**Application by North Somerset District Council for an Order granting  
Development Consent for the Portishead branch line – MetroWest Phase 1**

**Issue Specific Hearing 2, Day 1, Monday 11 January 2021**

**Response to Action Points**

**Agenda item 4 - Permanent Public Right of Way Diversions and Alternatives**

NATIONAL CYCLE NETWORK
ROUTE 26 OVERBRIDGE
CROSS SECTION PLAN LAYOUT
M5

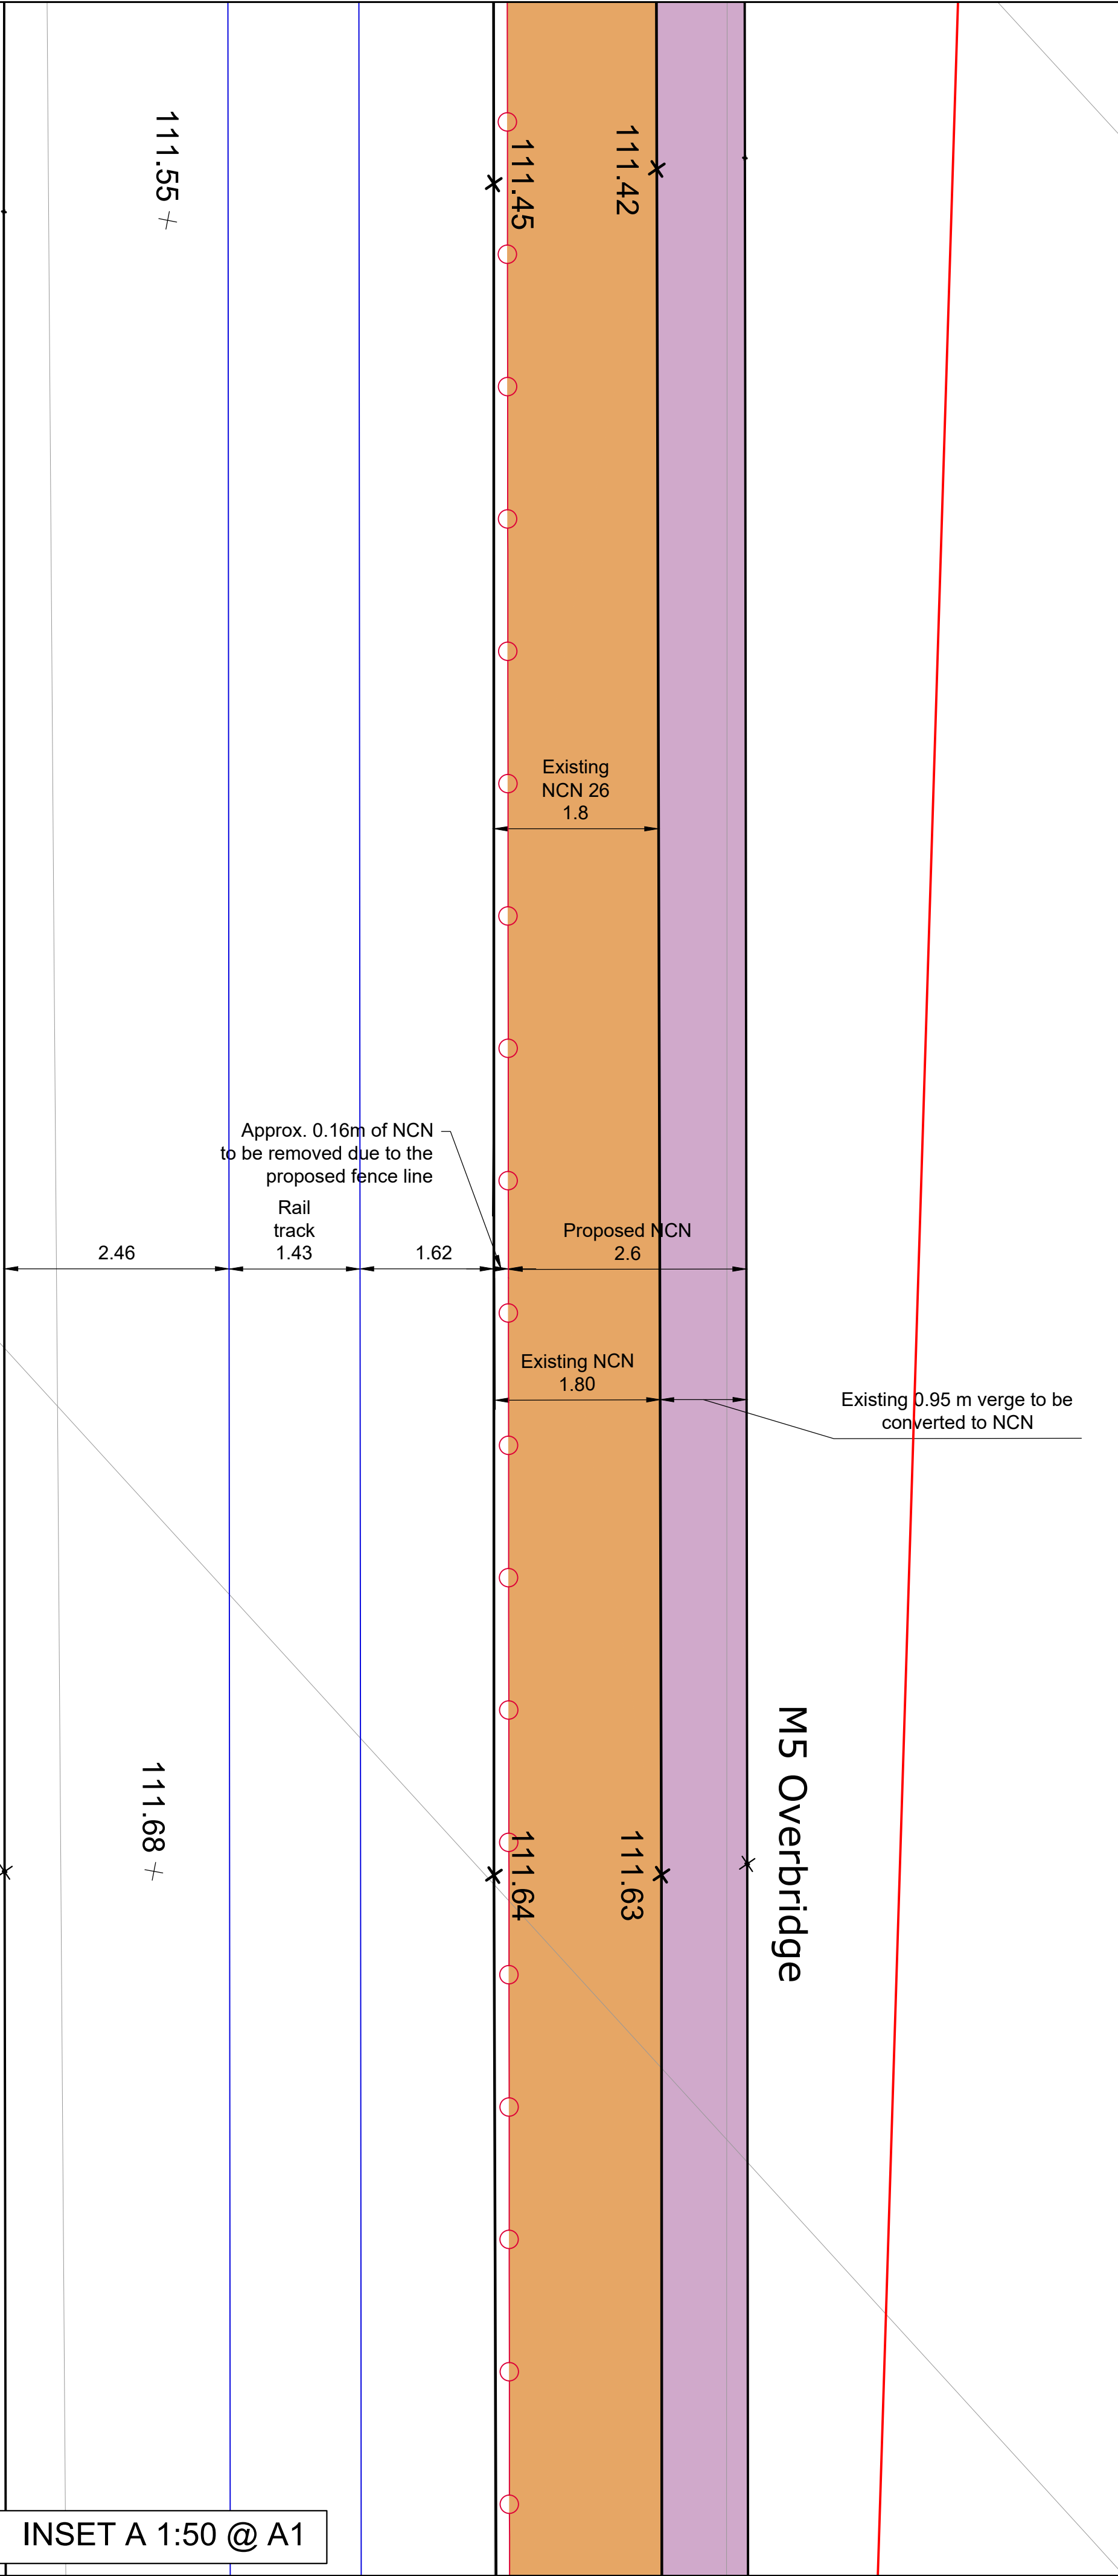
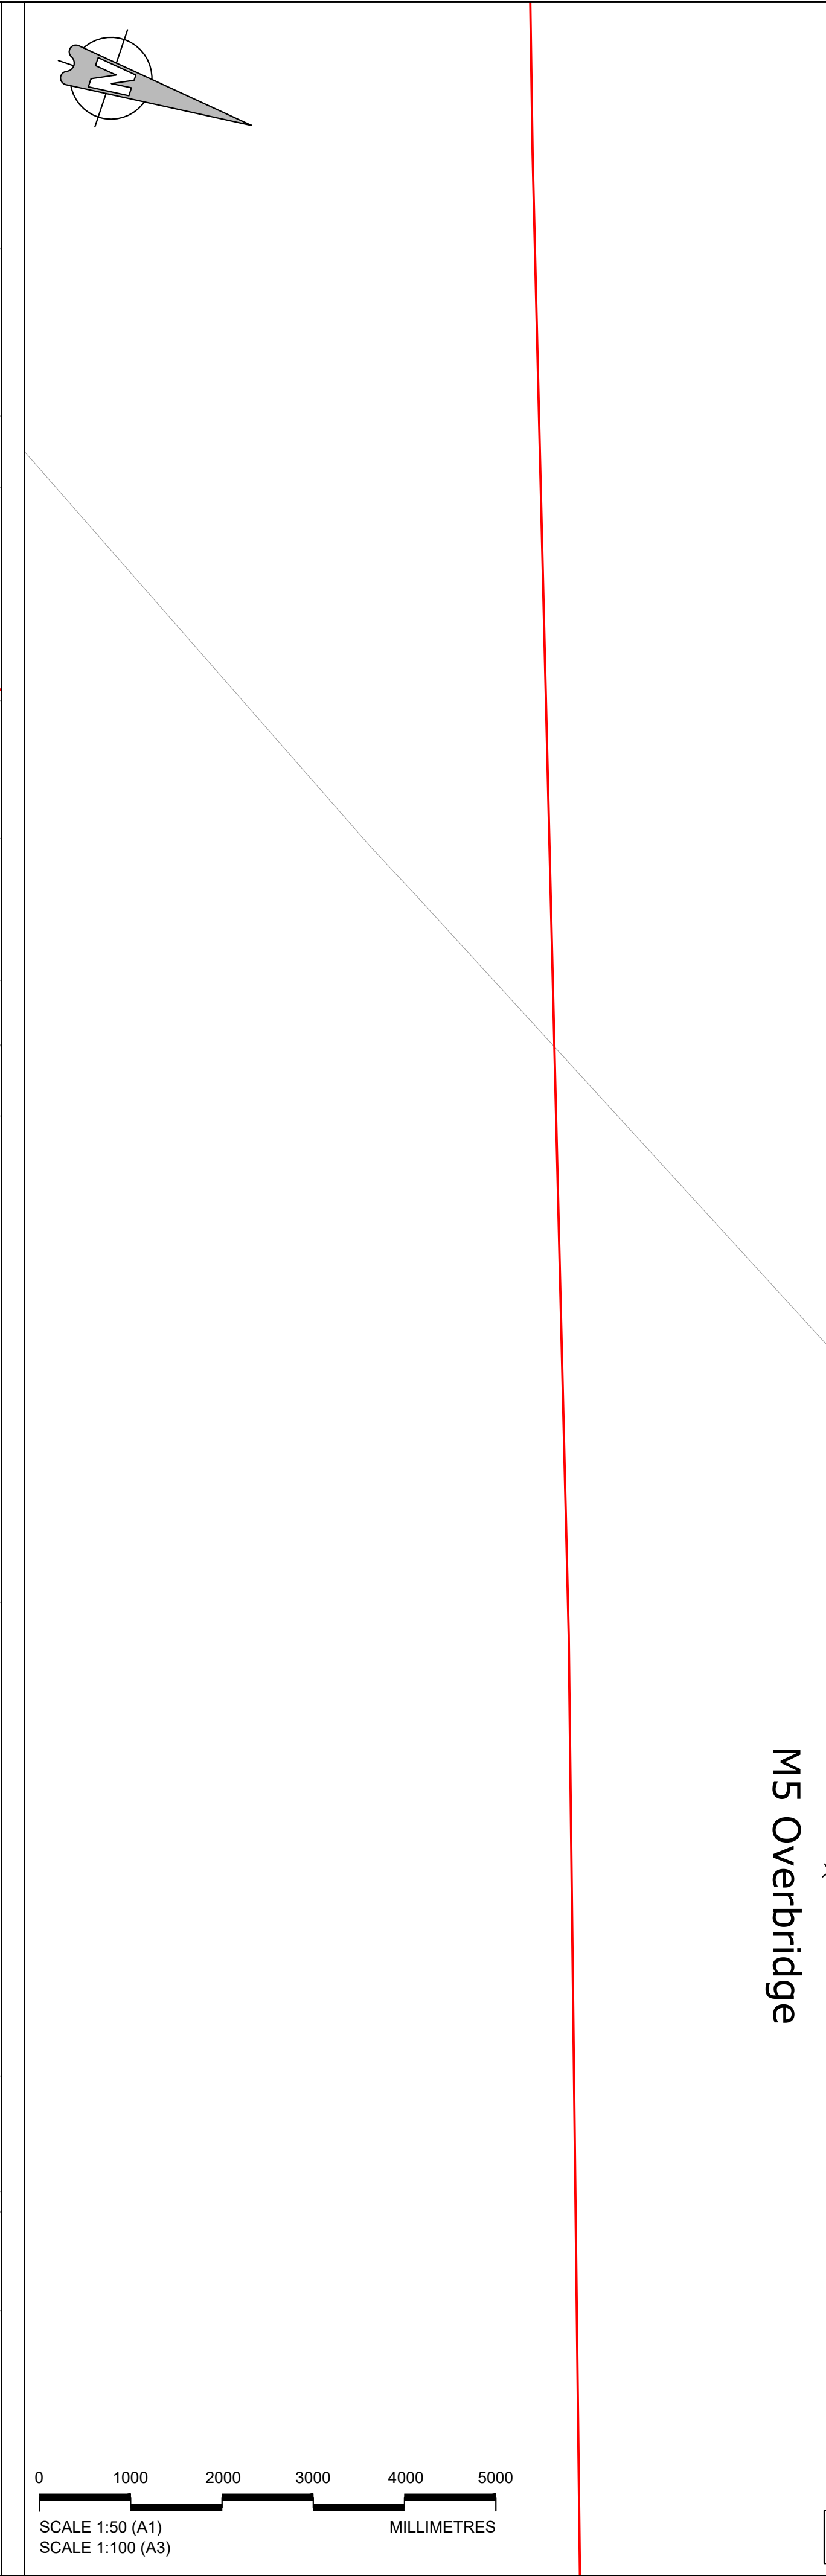
Currently, the disused railway and a permissive route run side-by-side through the M5 overbridge to the west of Pill. This permissive route is heavily utilised by pedestrians and cyclists on national cycle way NCN 26 and, occasionally, by horse riders. The bridge is effectively a short, narrow tunnel about 50 metres long. It is believed that, once MetroWest construction is complete, the intention is for the permissive way to be reopened. It is recognised that an alternative, longer route, bypassing the overbridge to the north, will be provided by the proposed re-routing of the bridleway. However, if the pedestrian/cycle route is to be retained in close proximity to the operational railway, then a significant health and safety issue would result for any people and animals who were on the path inside the M5 overbridge when a train transited under the bridge due to the deafening noise levels that would inevitably be generated. The length of the bridge is such that it might not be possible for many people to get out of the "tunnel" in time even if a train was heard to be approaching. Accordingly, if the permissive route is to be retained, then an acoustic barrier should be installed for the full length of the overbridge to shield pedestrians, cyclists and animals from the noise caused by the passage of the train. Of course, an alternative solution would be to close that section of the permissive route and oblige all users to use the diverted bridleway but that is not shown as being the case in the DCO. Of course, it would be necessary to ensure that the re-routed bridleway would be compatible with simultaneous use by pedestrians, cyclists and horse-riders.

NATIONAL CYCLE NETWORK
ROUTE 26 TEMPORARY DIVERSION
WORKS MARSH LANE

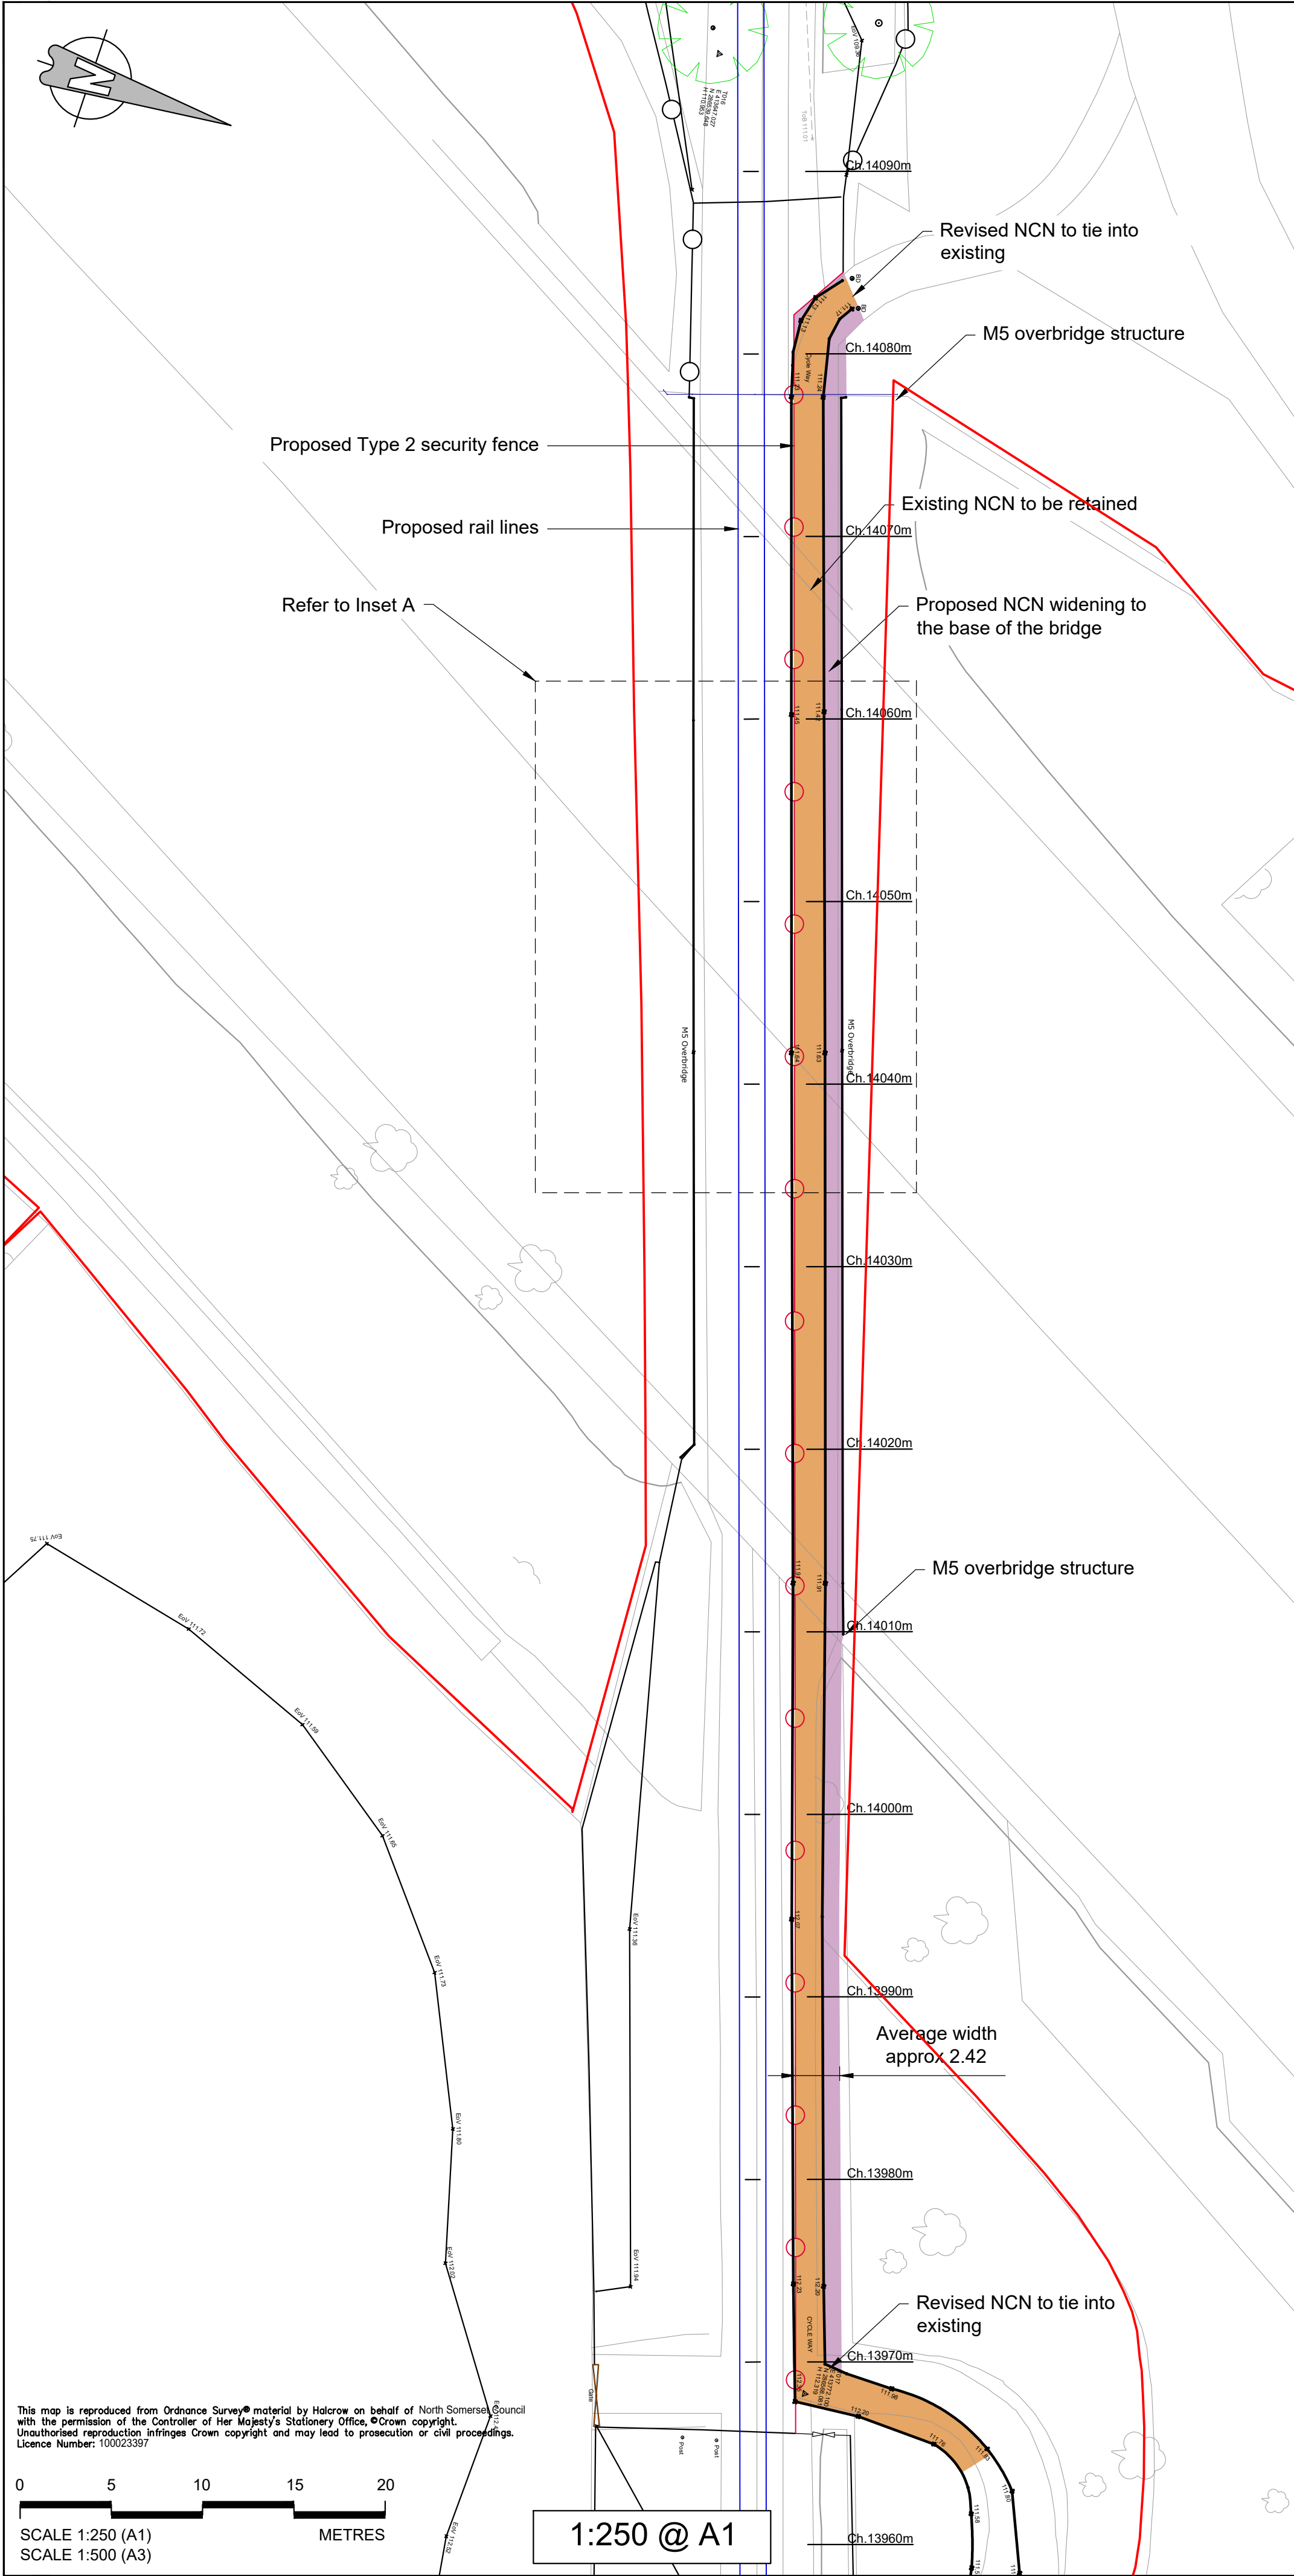
Mr Ovel raised his concerns about the proposal to divert NCN26 southbound from its junction with Marsh Lane to the junction with Church Road in Easton-in-Gordano. I to share his concerns on grounds of user safety having experienced several near misses as a regular user of this route. The Applicant's representative (Mr Wilcock, NSDC) expressed an opinion that because Marsh Lane is a minor route, the proposed diversion would not significantly increase the hazard to users of the diverted section of NCN 26. With this statement I must disagree.

As Mr Ovel; I too, walk this road several times a week to access the cycle path/ NCN26. The majority the stretch of the diversion route is subject to a recently introduced 40 mph speed limit (previously 60mph), reducing to 30 mph just before reaching Church Road; why the whole road was not made subject to a 30 mph limit is another question. There is also a semi blind, narrow, hump-backed bridge on a bend over the railway. There is no footpath for a distance of 100+ metres either side of the bridge; although there are white lined "pedestrian refuge" areas recently added when the "Honda" traffic lights were installed near the cycle path crossing point on Marsh Lane. However; these white lined areas are on the opposite side of the road in each direction, so the user has to cross the road at the top of the hump back bridge.

This road is busy with local traffic accessing and exiting the dock area and J19 M5; and, non-local private and light commercial traffic both accessing and exiting the docks area, using Marsh Lane as a "rat run" to avoid delays at J19, particularly in peak periods; at times this road can best be described as a "speed track" with many vehicles ignoring the speed limit. As have previously mentioned, the cycle track/ NCN26 is becoming increasingly busy, with horse riders, walkers, runners and cyclists; the latter of which can be individuals, or groups of varying sizes often multiple family groups, including children of all ages.

I would also like to point that the entrance point to the cycle path/ NCN26 in Marsh Lane is almost directly opposite what will be Access Point AW 5.1, which provides access the proposed Haul Road to the construction compounds under the M5 Avonmouth Bridge and Lodway Farm; again, causing direct conflict between users of the cycle path/NCN26 and construction traffic.

As per Mr Ovel, I agree it would be unwise to re direct any users of the cycle path/ NCN26, on to Marsh Lane placing them in conflict with fast moving traffic for several hundred metres on a narrow road with a view restricted crest over the bridge. I share Mr Ovel's opinion a lot more work would have to be done to make this diversion route safe. A further reduction to a blanket 30 or 20 mph limit would be a good start, combined together with speed reduction measures such as speed humps and warning signage. Perhaps making Marsh Lane "one way" to motor traffic might be worthy of consideration; or, as it is deemed only a "minor" route, perhaps temporary closure of this stretch of Marsh Lane should be considered, with traffic affected being redirected to the main primary routes in an out of Pill/ Easton In Gordano and Royal Portbury Dock. This last option would also prevent any construction traffic the ability to use this stretch of Marsh Lane.
